Submission for Job: #6010 SSD 6010 - One Residential Building (Student Accommodation) within Darling Drive Plot

**SSD 6010 - One Residential Building (Student Accommodation) within Darling Drive Plot**

**30 July 2013**

SHADOW DIAGRAMS: PLAN SHOWING THE HAYMARKET, WINTER SOLSTICE

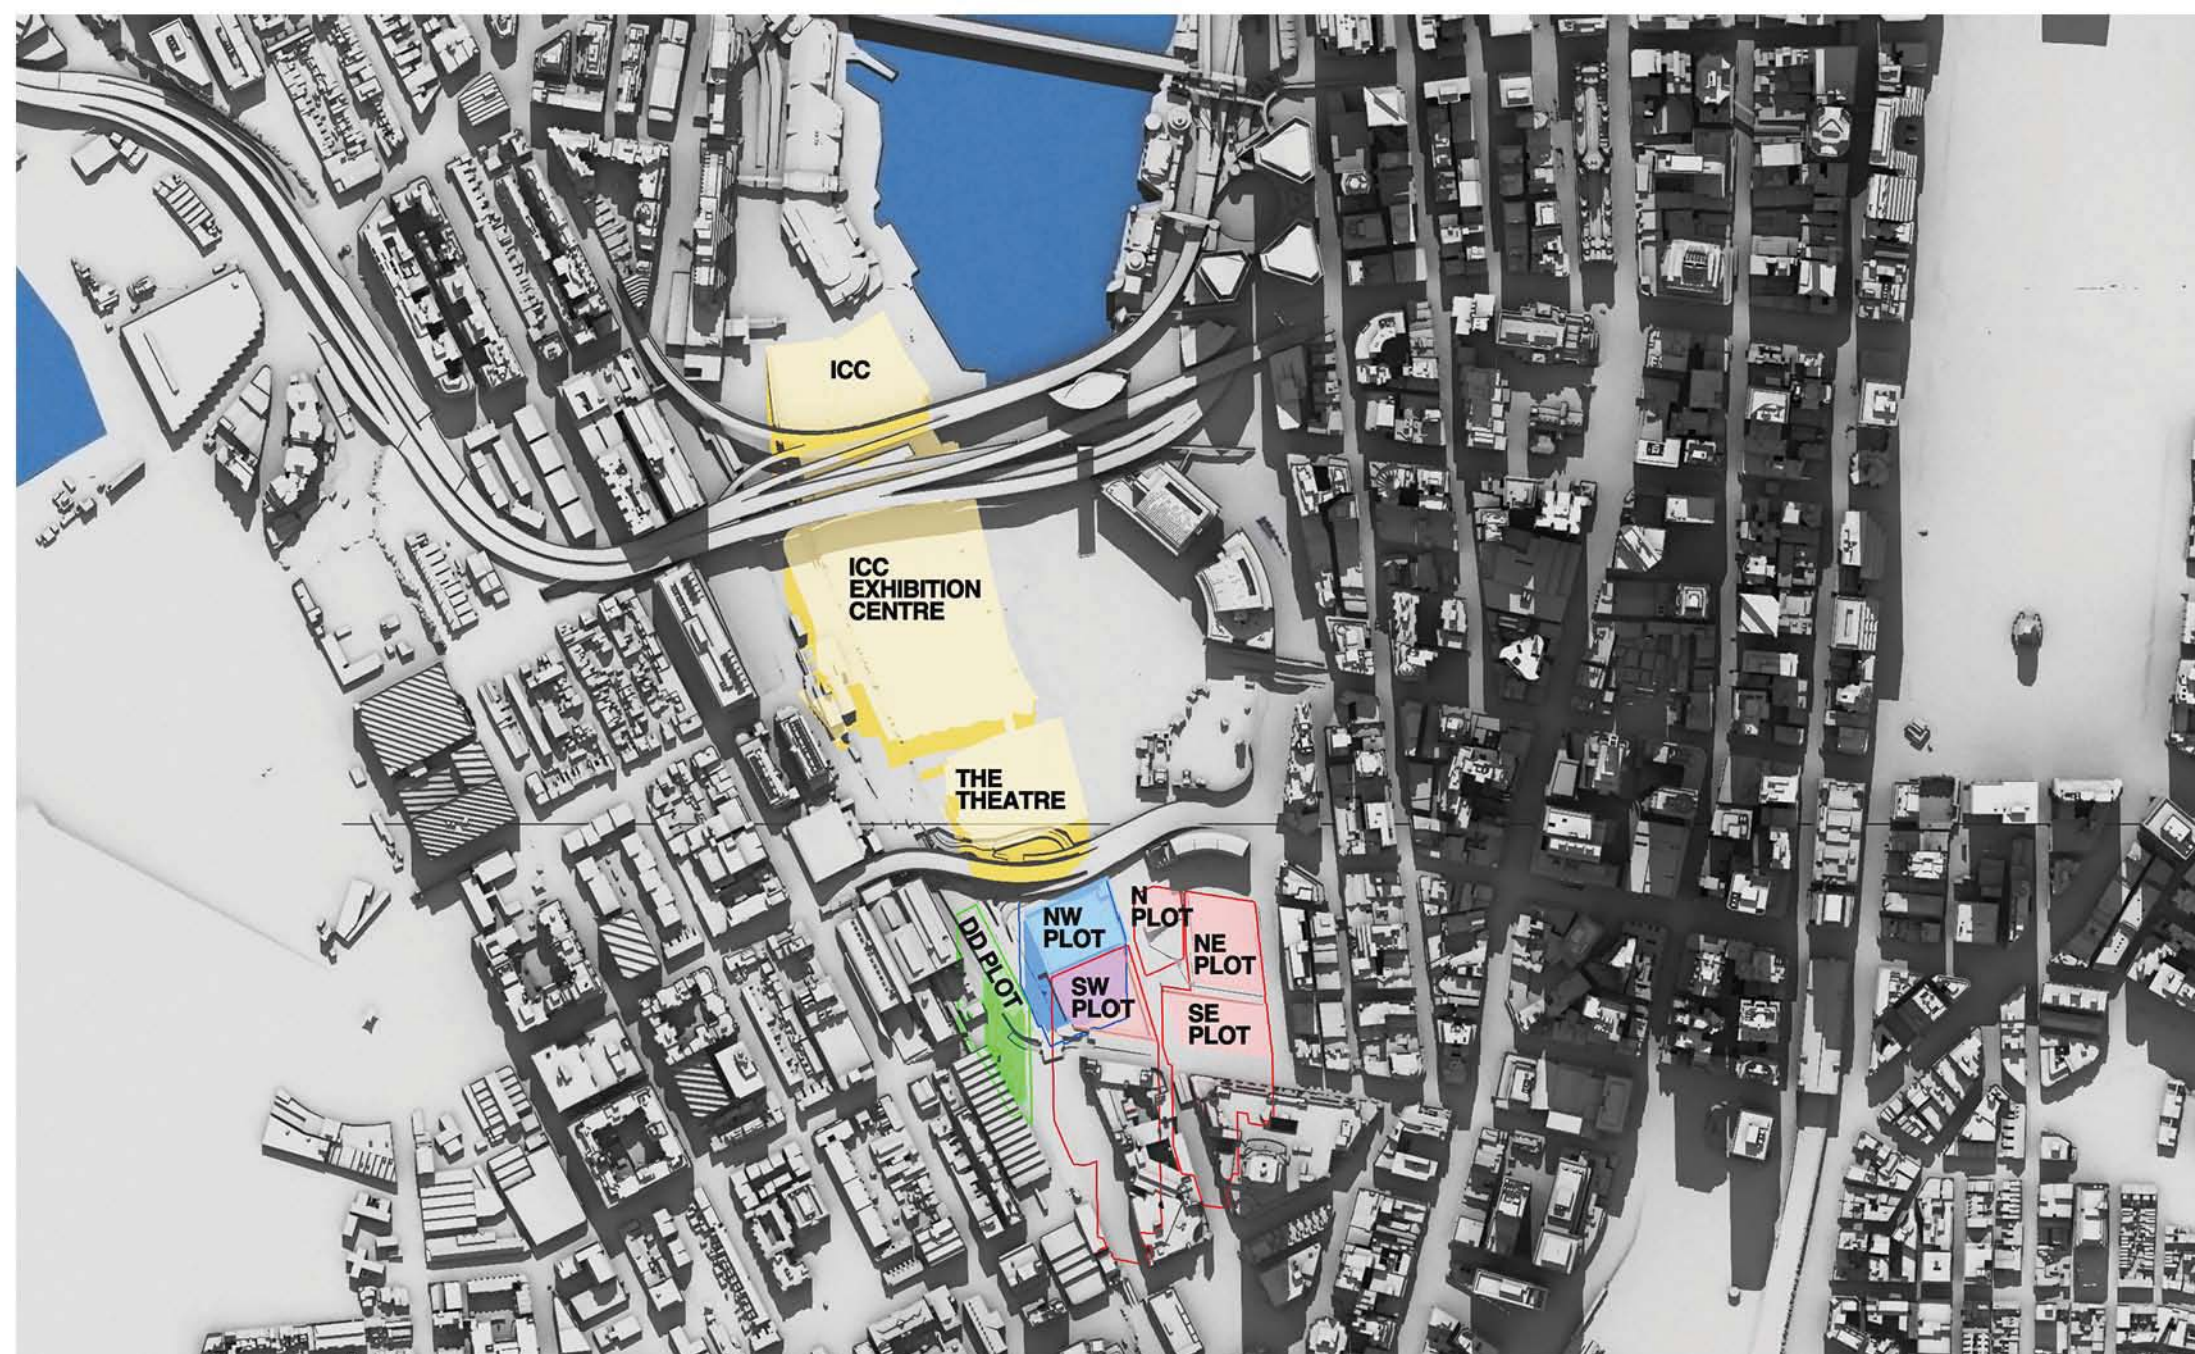
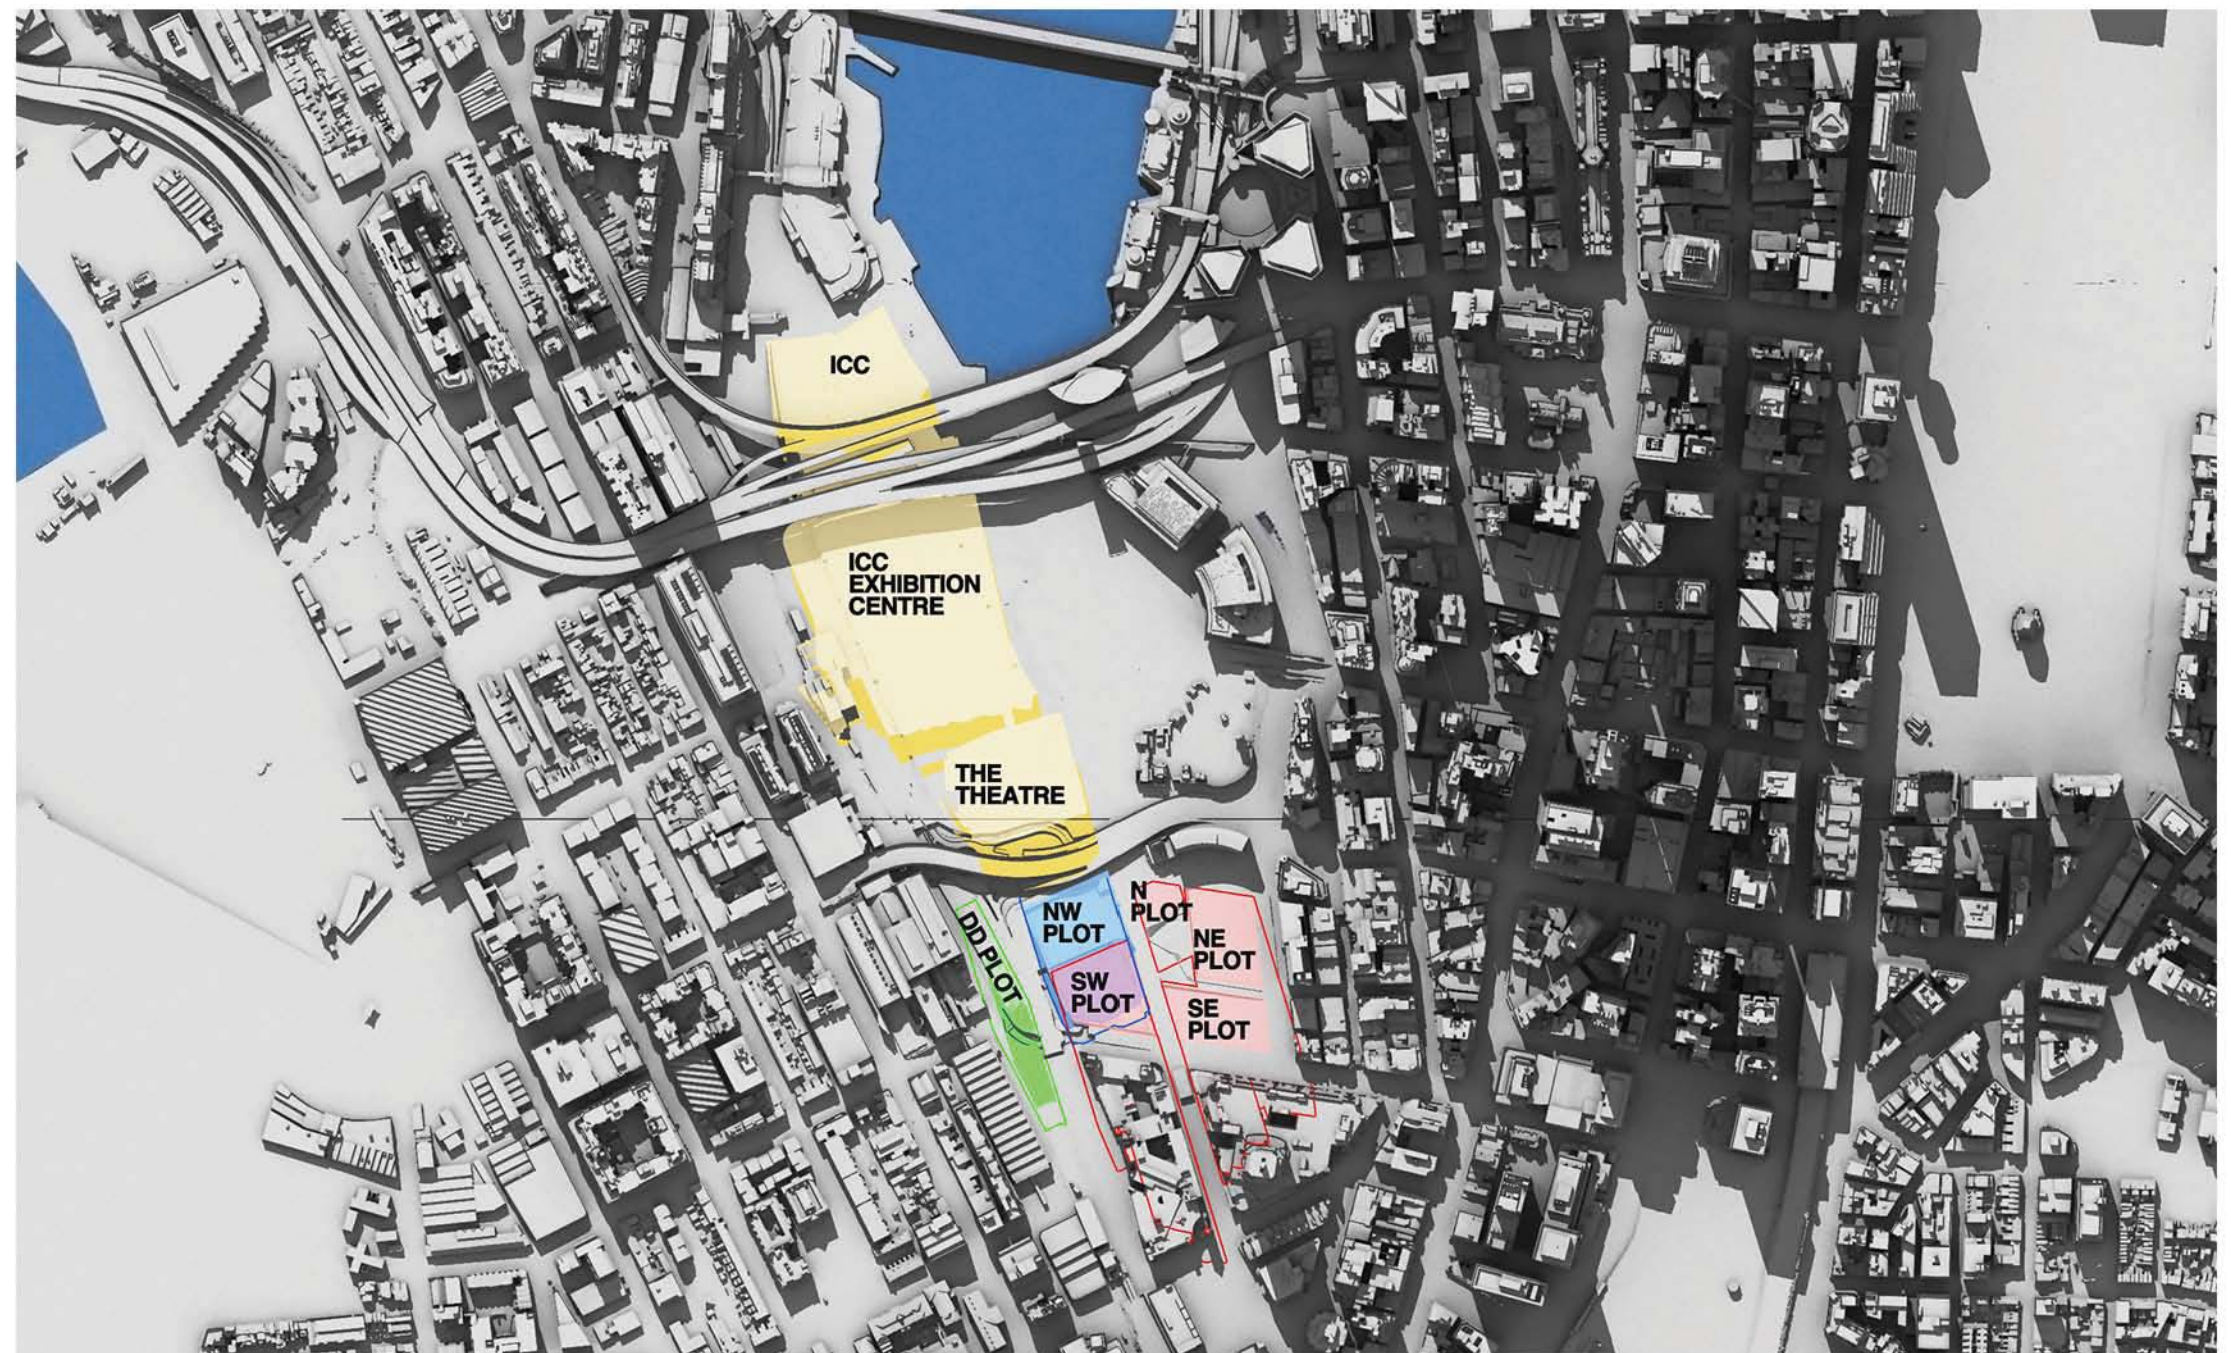
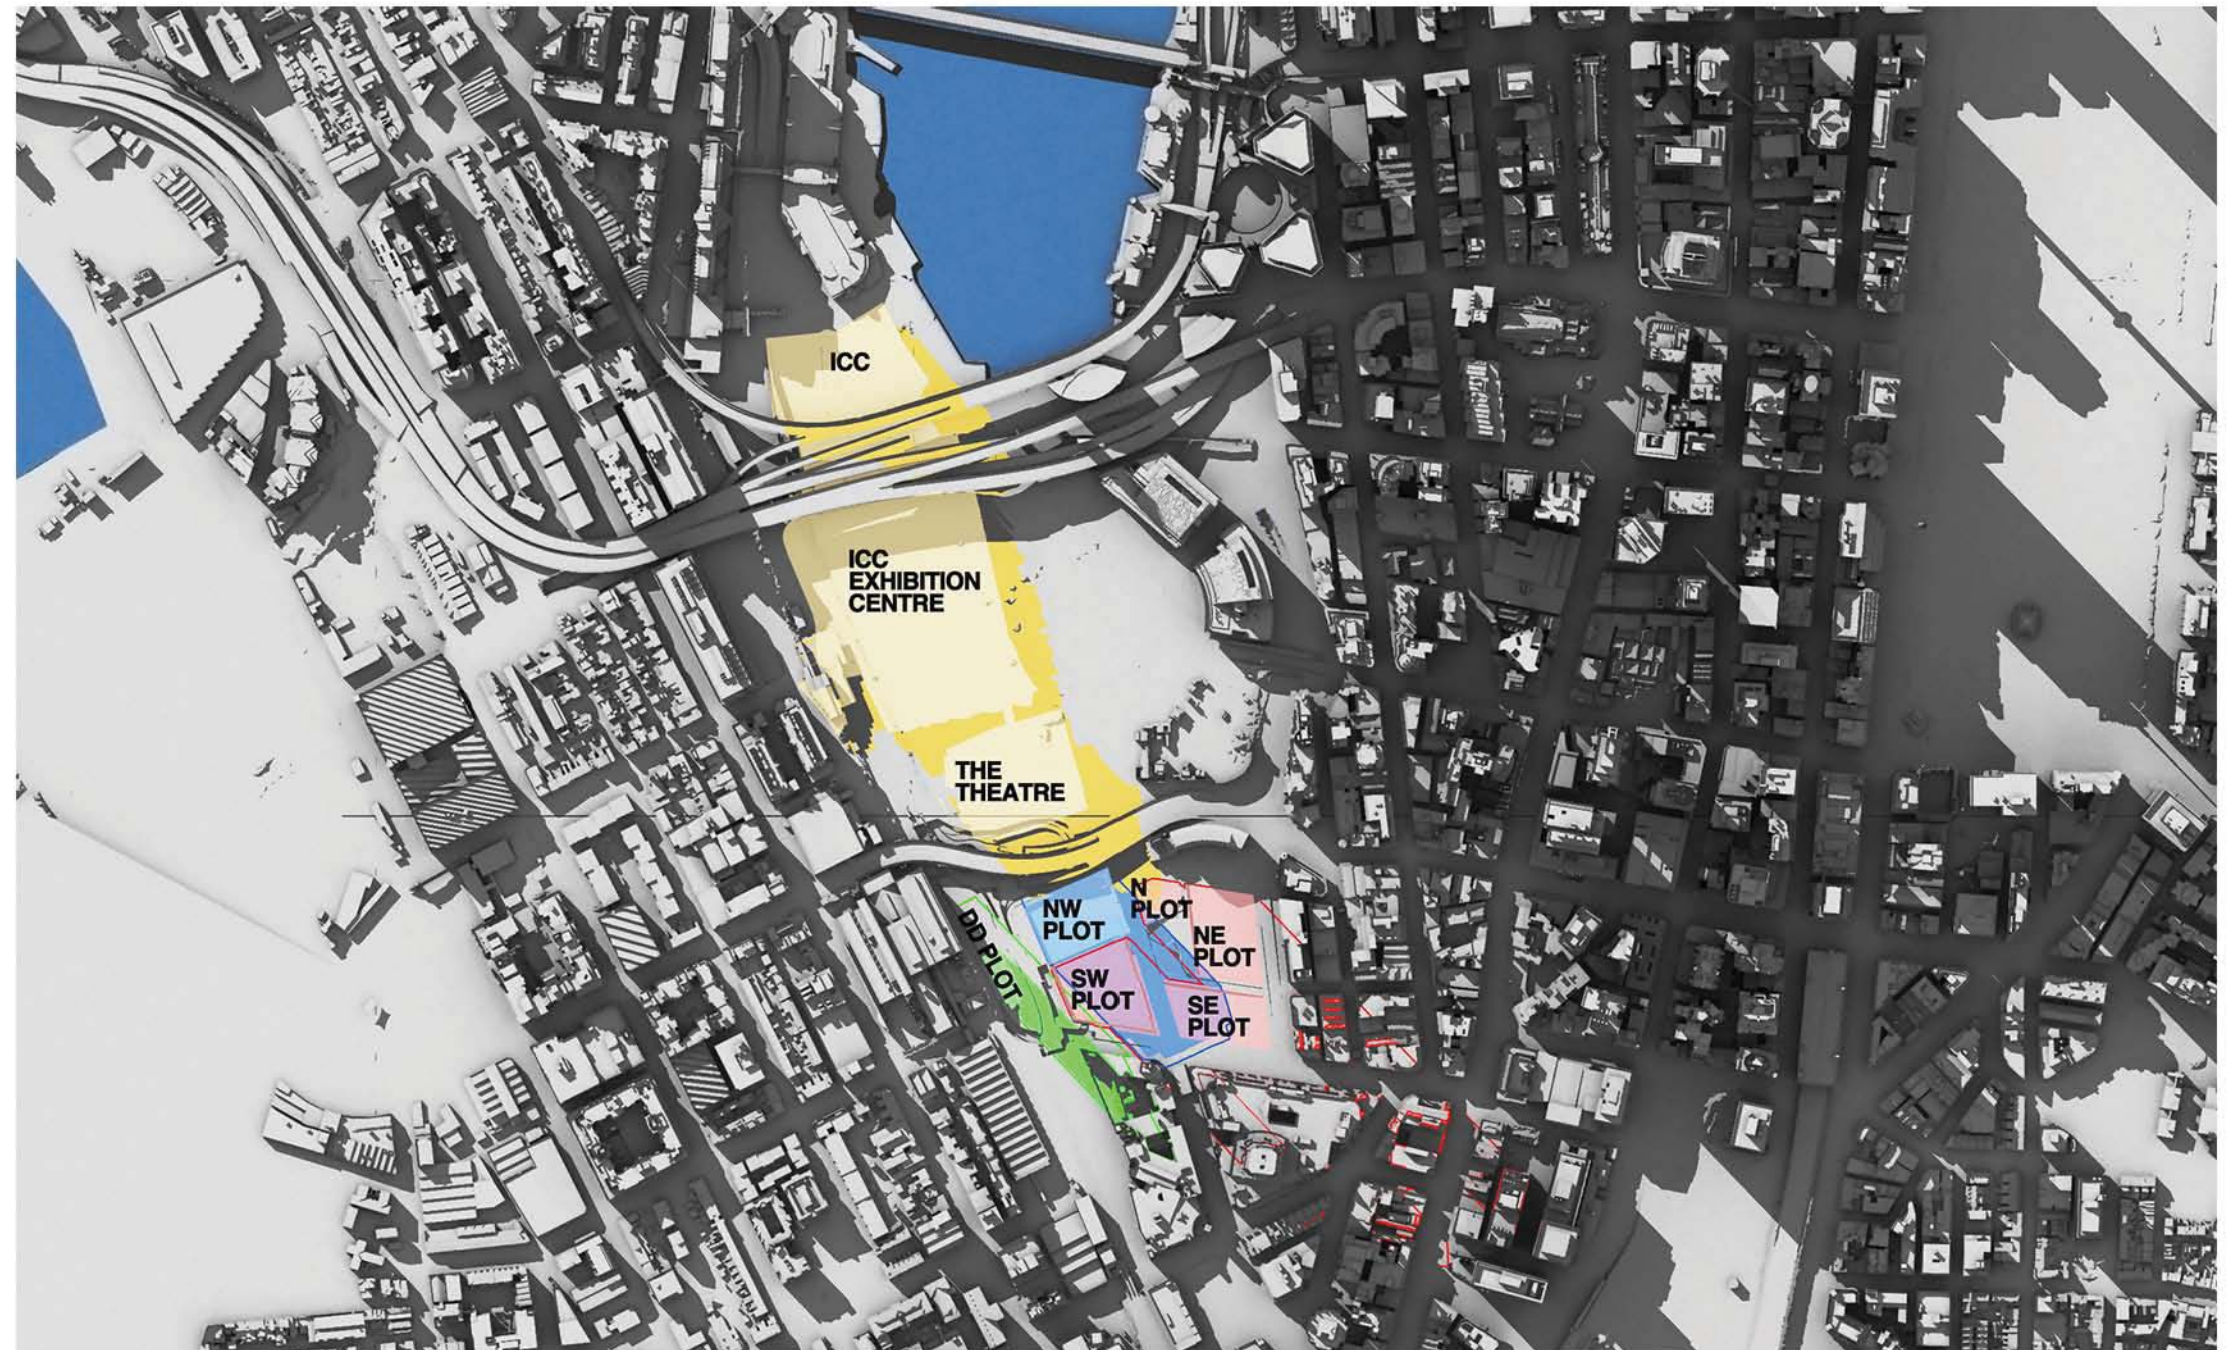
At 9am, 10am and 11am the west façade is totally in shadow due to other parts of The Peak building itself.

At 12pm there is still substantial existing shadowing on the west façade caused by the irregular shape of the west facade.

At 1pm the existing shadowing has been substantially removed, but not totally removed.

By 2pm the existing shadowing has been totally removed, but that is too late to achieve two hours of direct sunlight before 3pm.
